Date: 9 August 2018

Planning Act 2008 – Section 51

Application by Suffolk County Council for an Order Granting Development Consent for the Lake Lothing Third Crossing

Advice following issue of decision to accept the application for examination

NOTES:

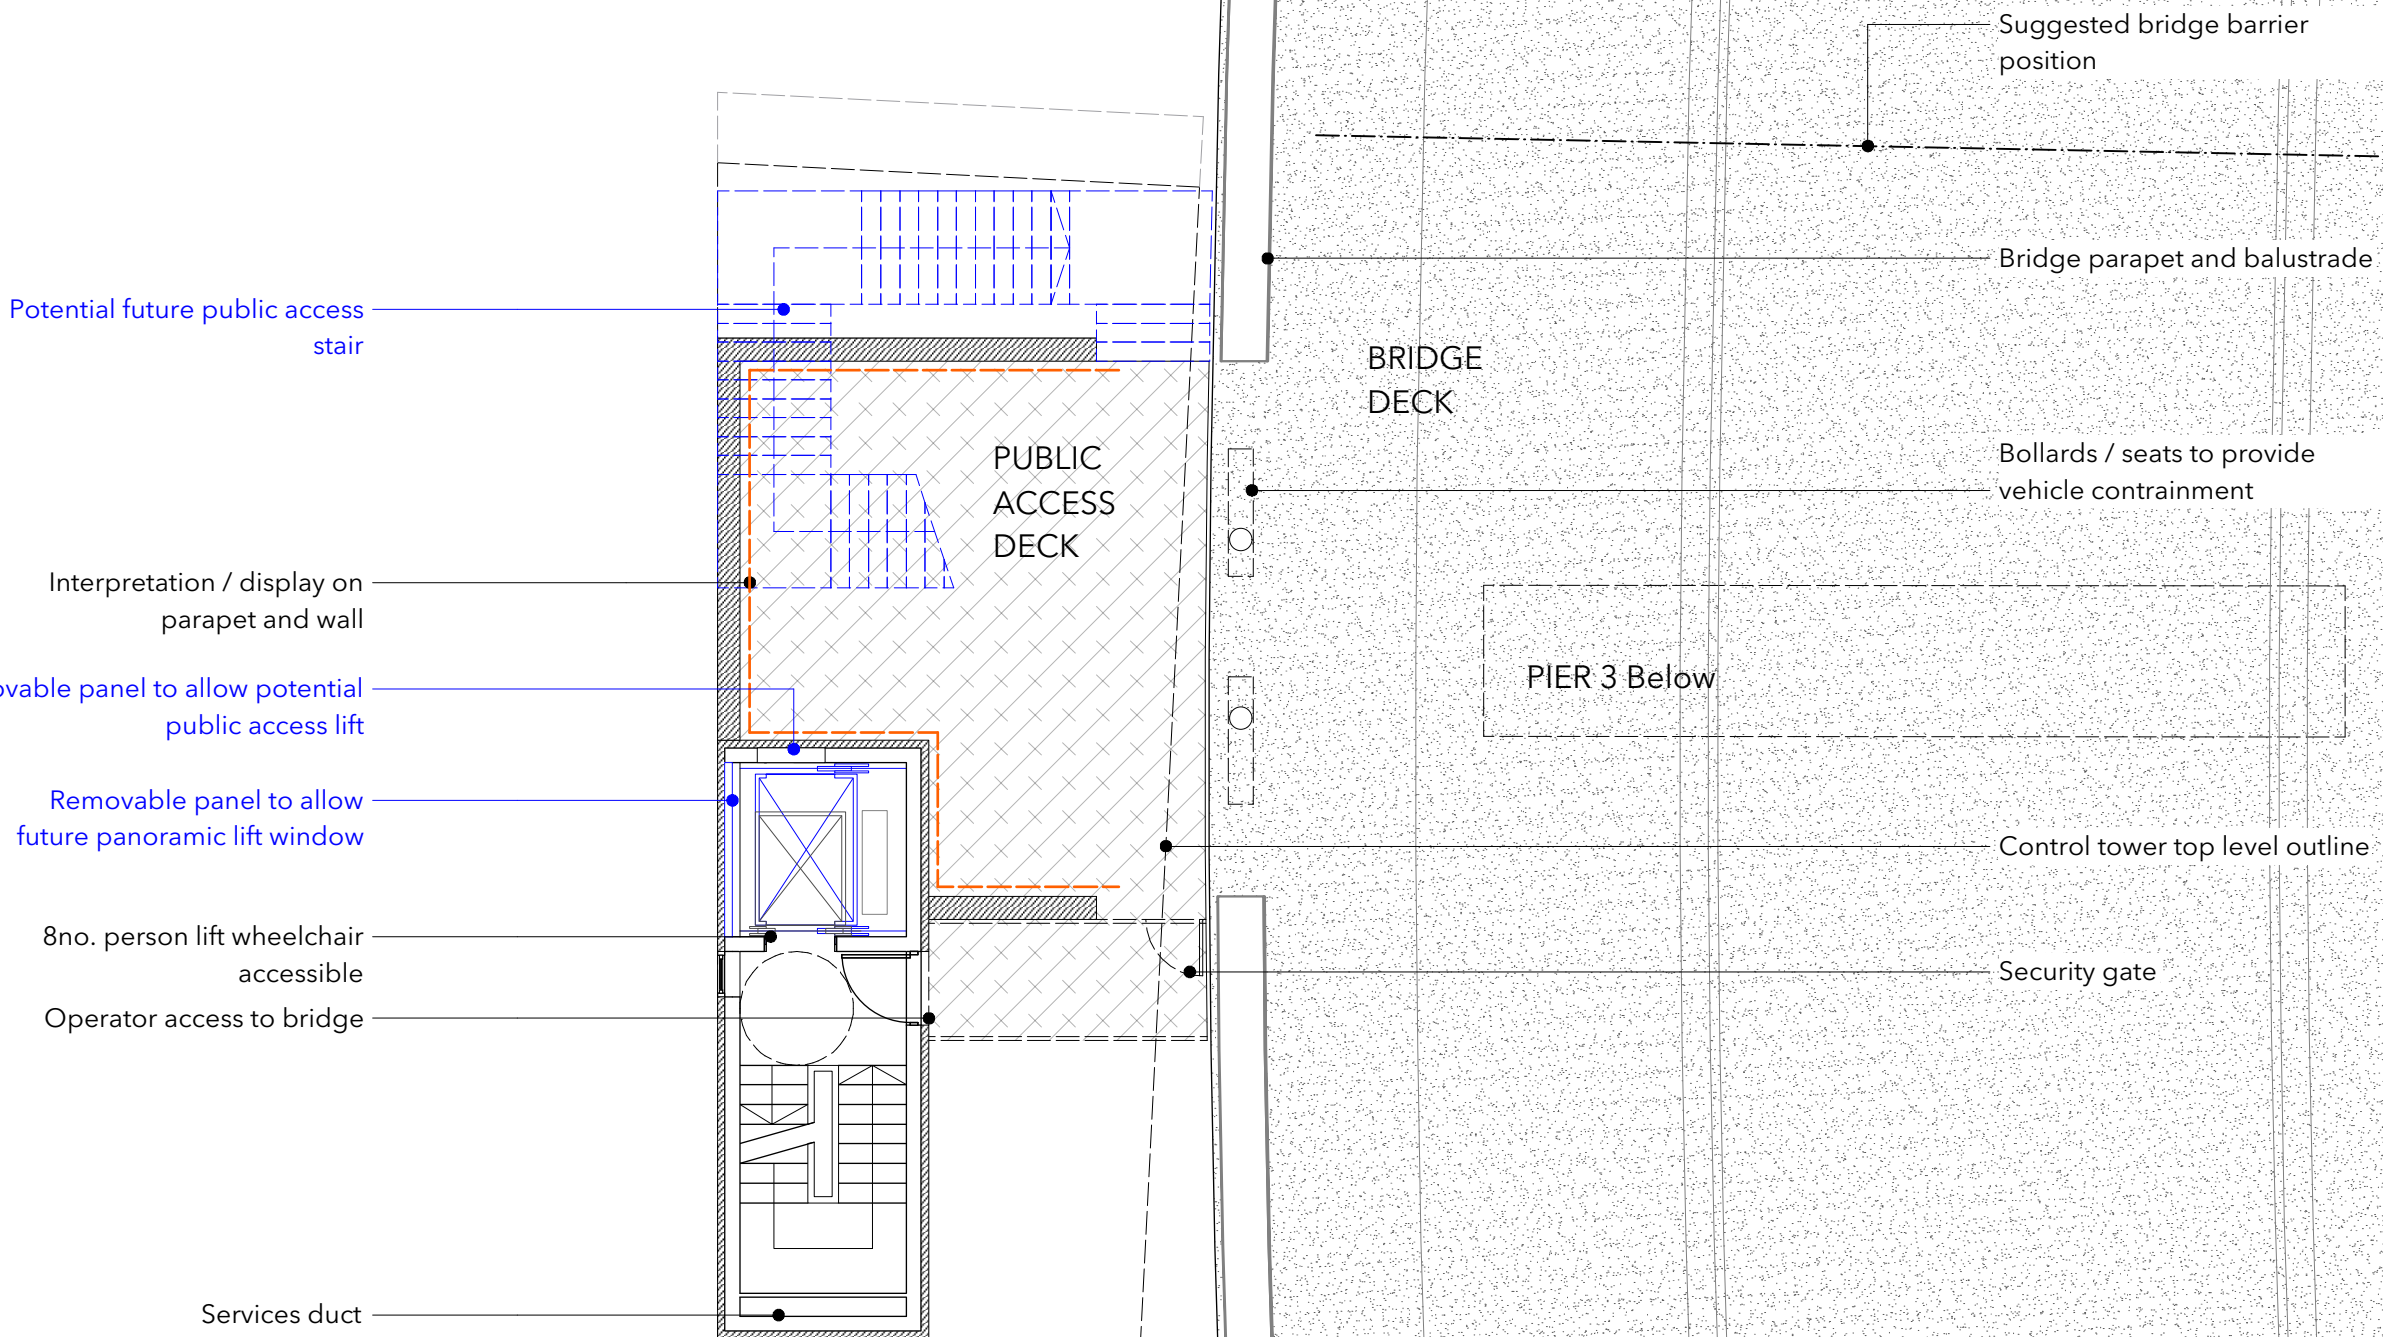
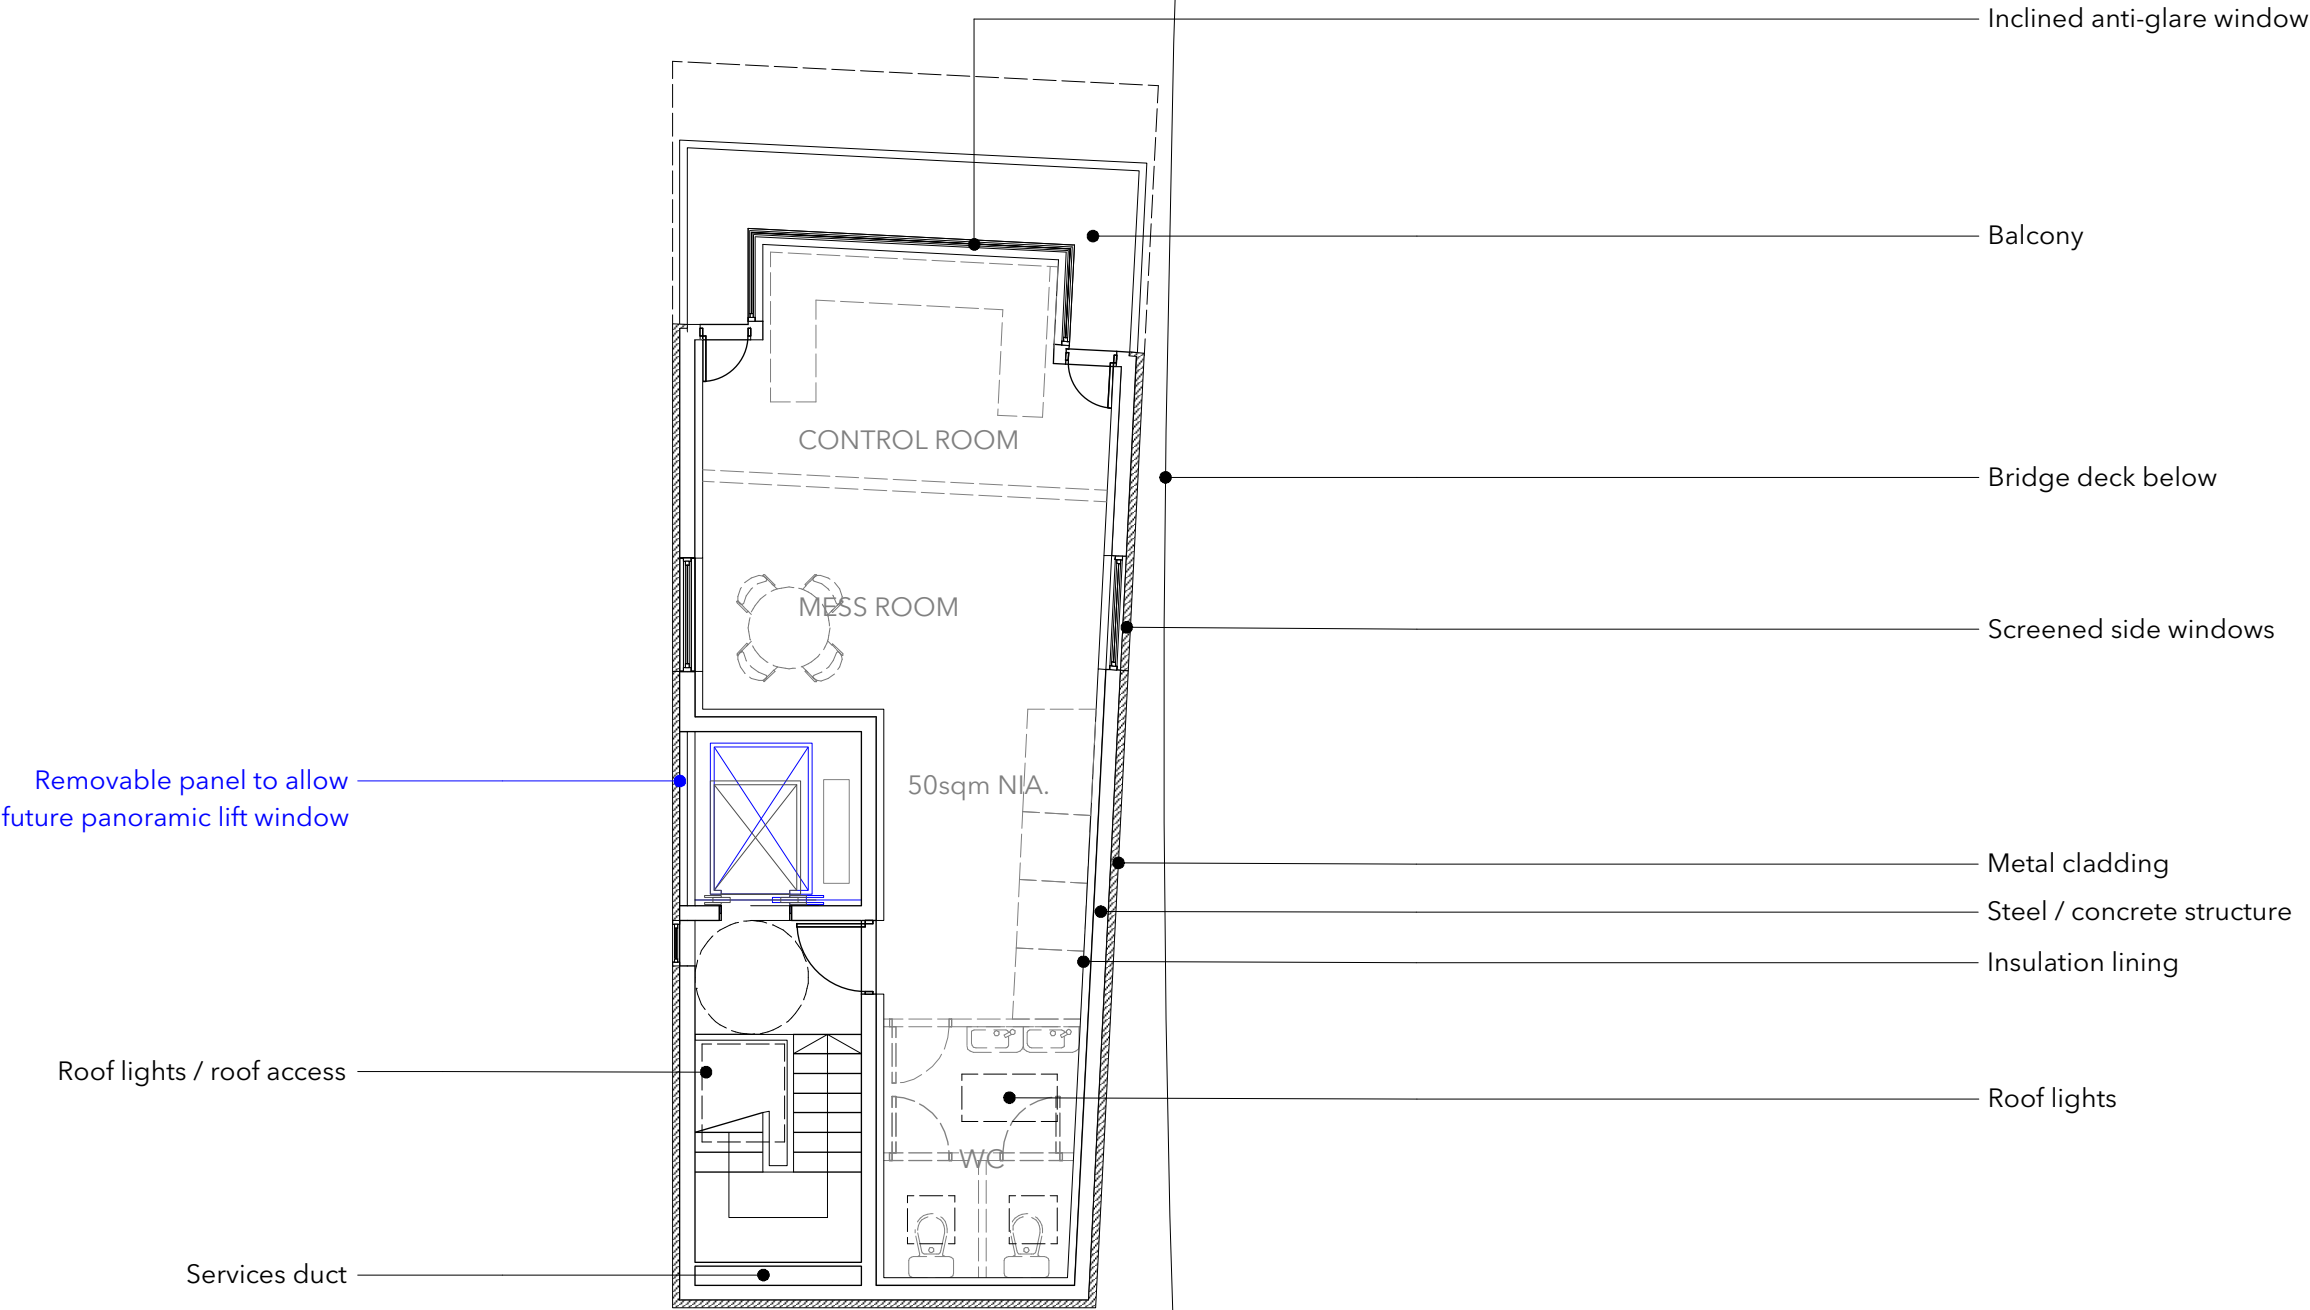
The Applicant is advised that the appointed ExA may request for the provision/ preparation of detailed technical plans and elevations for the design of the bridge, the bridge abutments and the control tower to inform the examination of design matters.
